City of Albuquerque

Re: MEINEKE MUFFLERS
1812 Juan Tabo Blvd. NE
Approval of Permanent Certificate of Occupancy (C.O.)
Engineer's Stamp dated 10/20/2003 (H-22/D072)
Certification dated 05/01/2004

Based upon the information provided in your submittal received 05/18/2004, the above referenced certification is approved for release of Permanent Certificate of Occupancy by Hydrology.

SHEET TITLE:
GRADING AND DRAINAGE PLAN

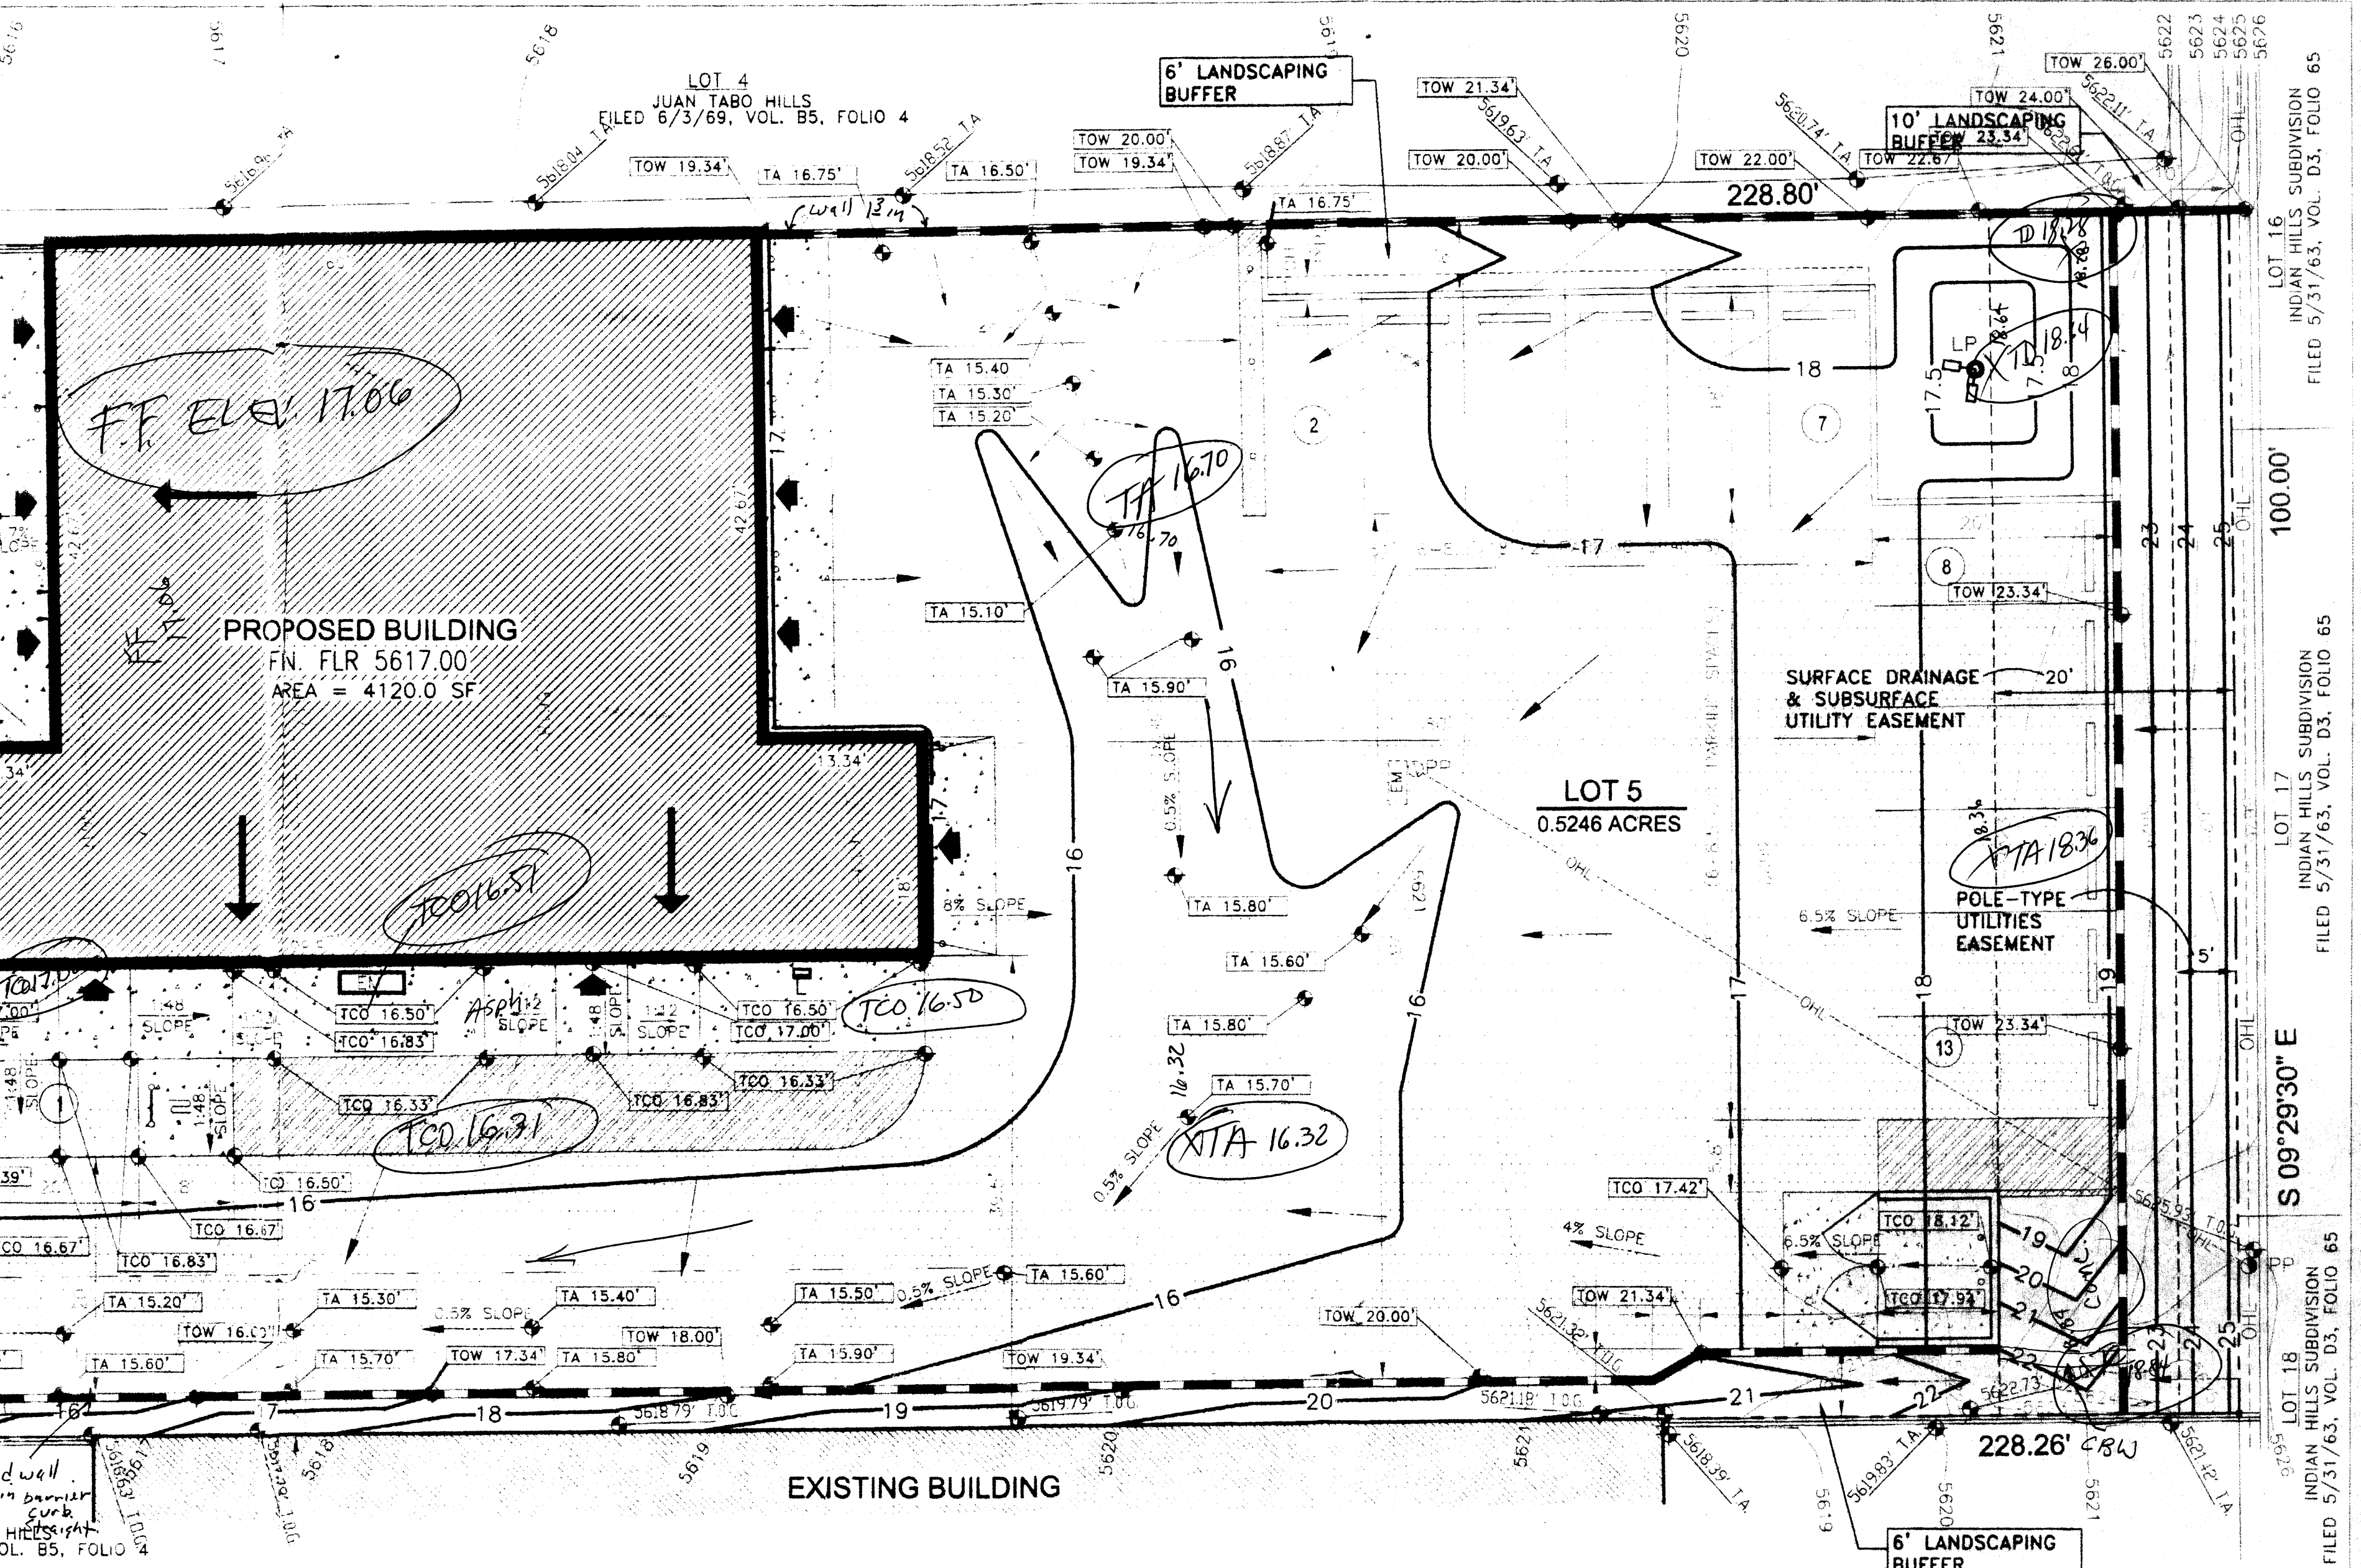
1. Please show the roof flows for the proposed building.
